Project: Somers Residence-Peaks Island Architect: Whitten Architects

110 Ledgewood Road
 Peaks Island, Portland, Maine

RE: Application for Minor Site Plan, 110 Ledgewood Street, Peaks Island
(CBL#087E002) (ID#2004-0099)

Thank you for your application for the 110 Ledgewood Street single-family house. Upon review of the site plan, the City has the following comments:

**SITE PLAN**

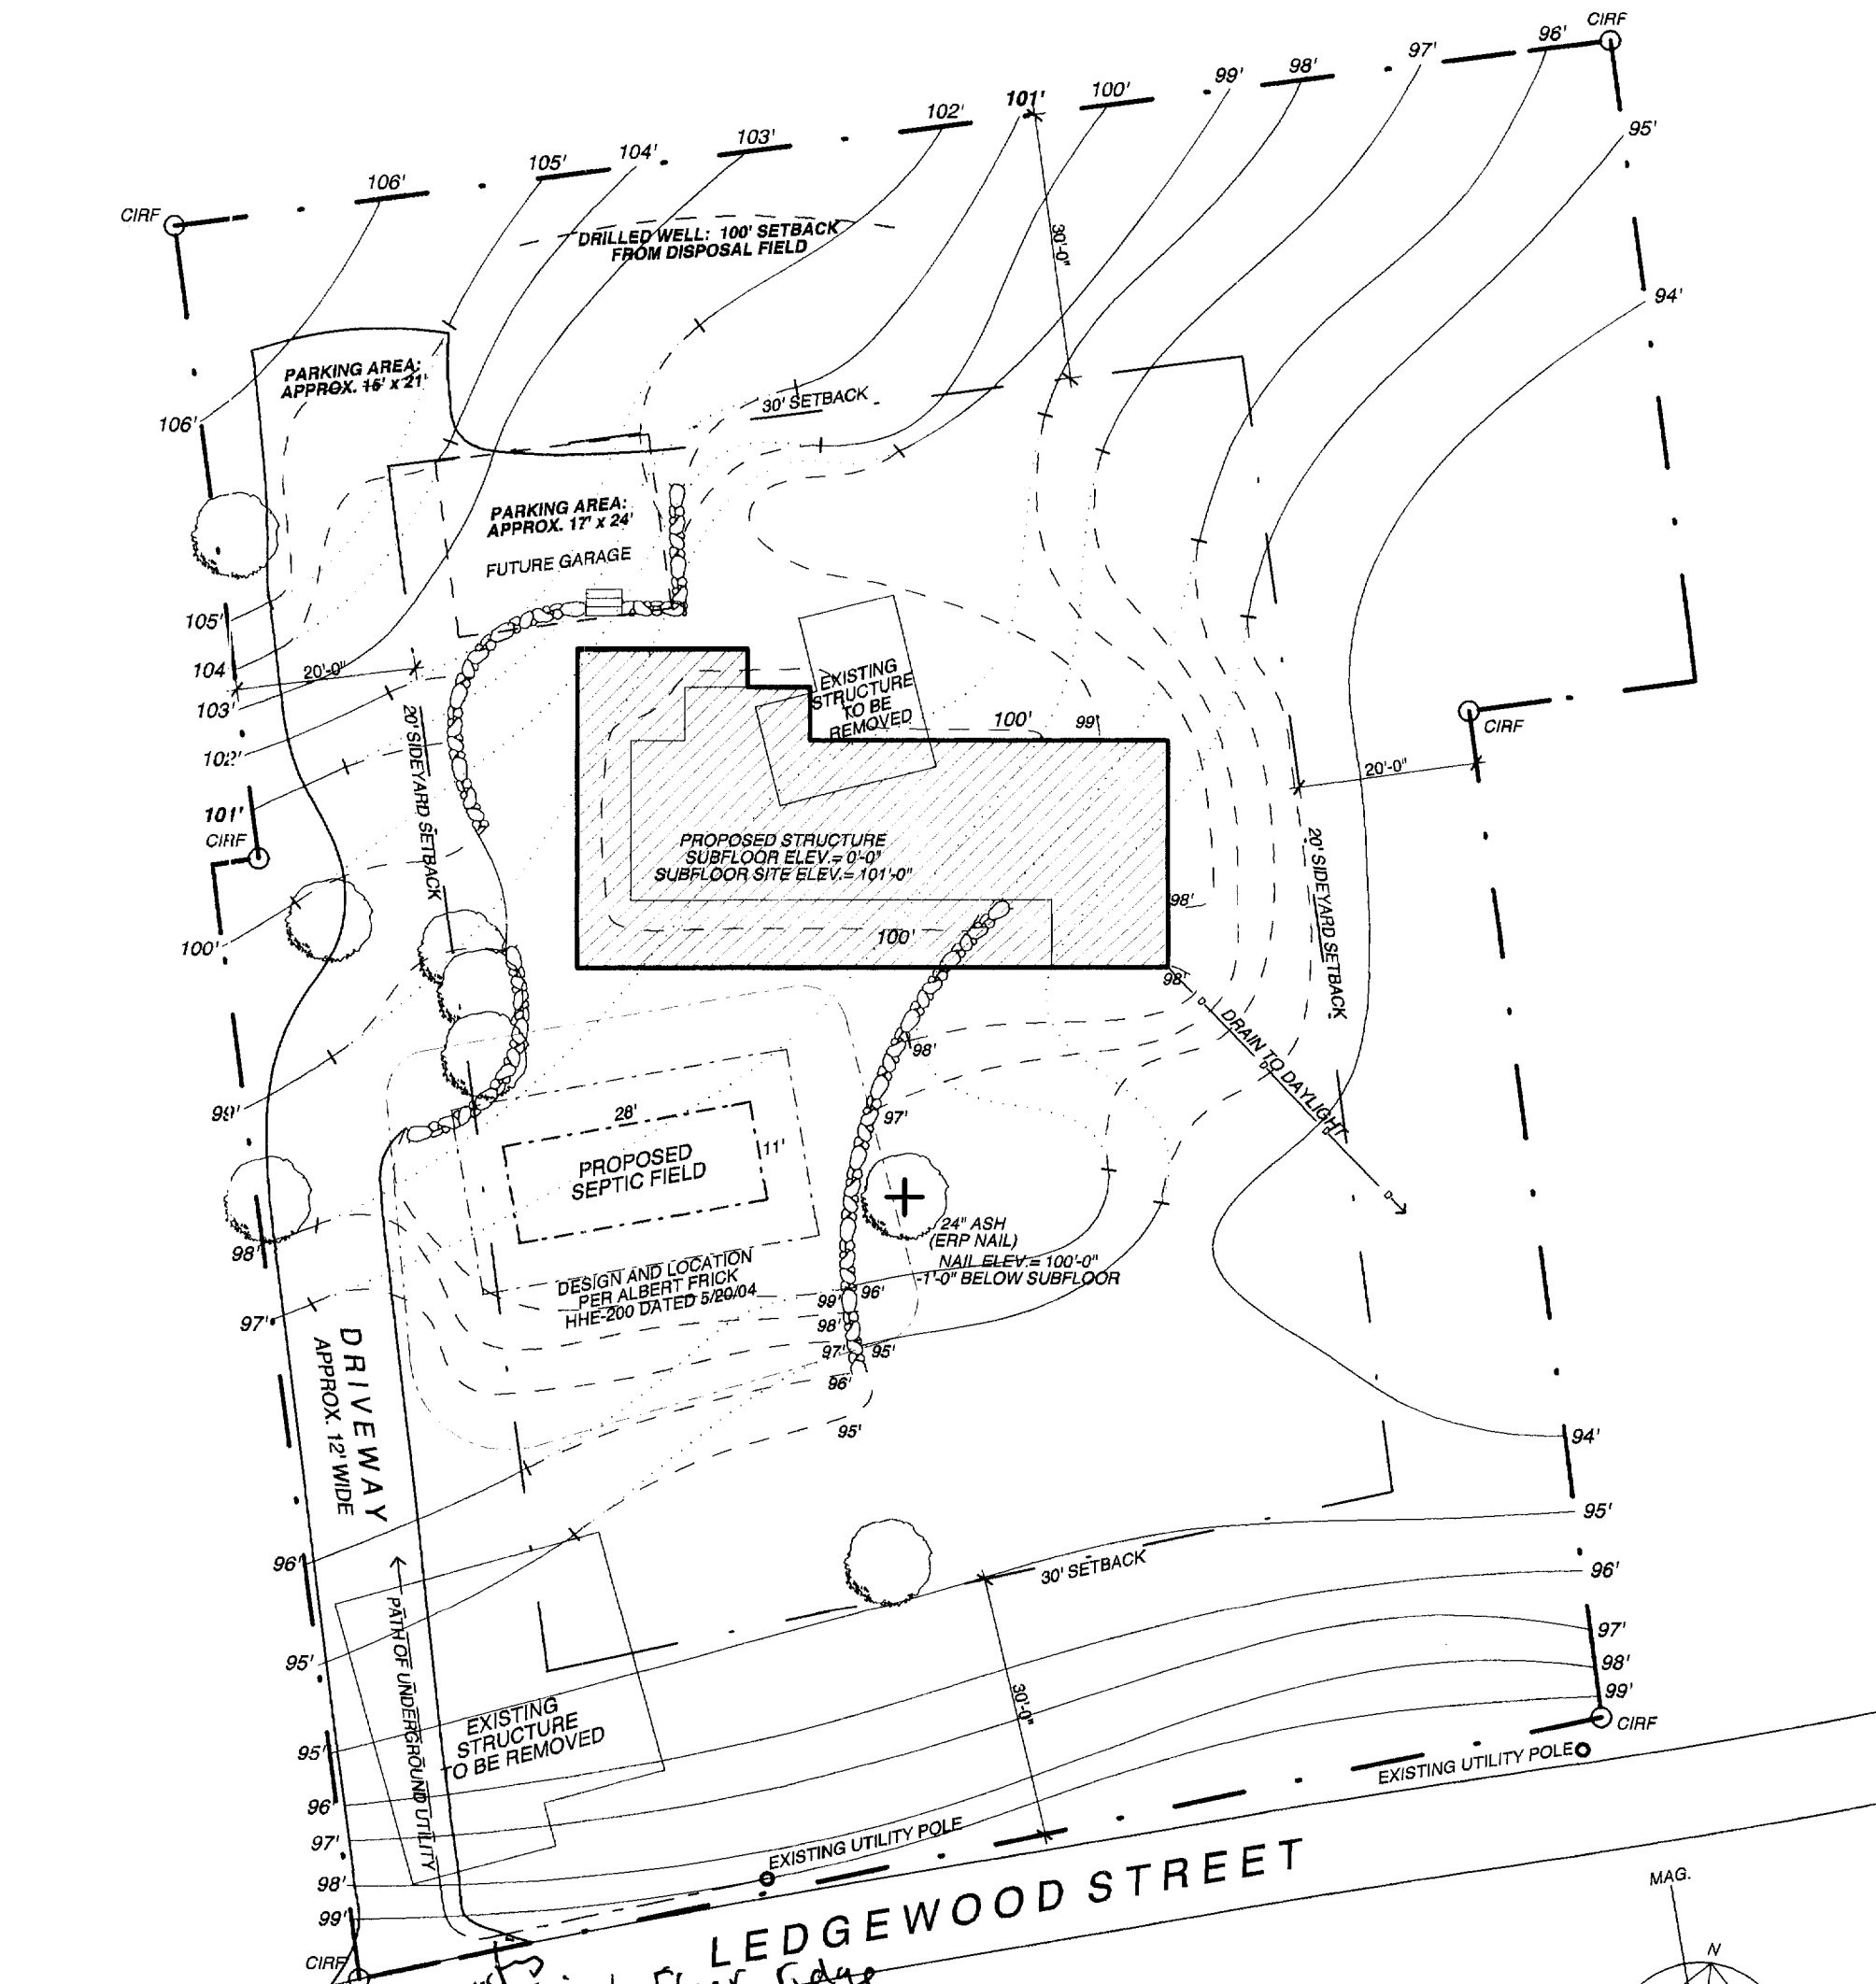
1. Please re-locate the proposed driveway so the apron does not encroach on the abutting property.
2. Please show silt fence/erosion control in its' appropriate locations on the site plan.
3. It appears that drainage, both existing and proposed, travels easterly. In order to prevent any drainage issues with the neighboring property, it is recommended that a dry well be installed at the outlet of the foundation drain.
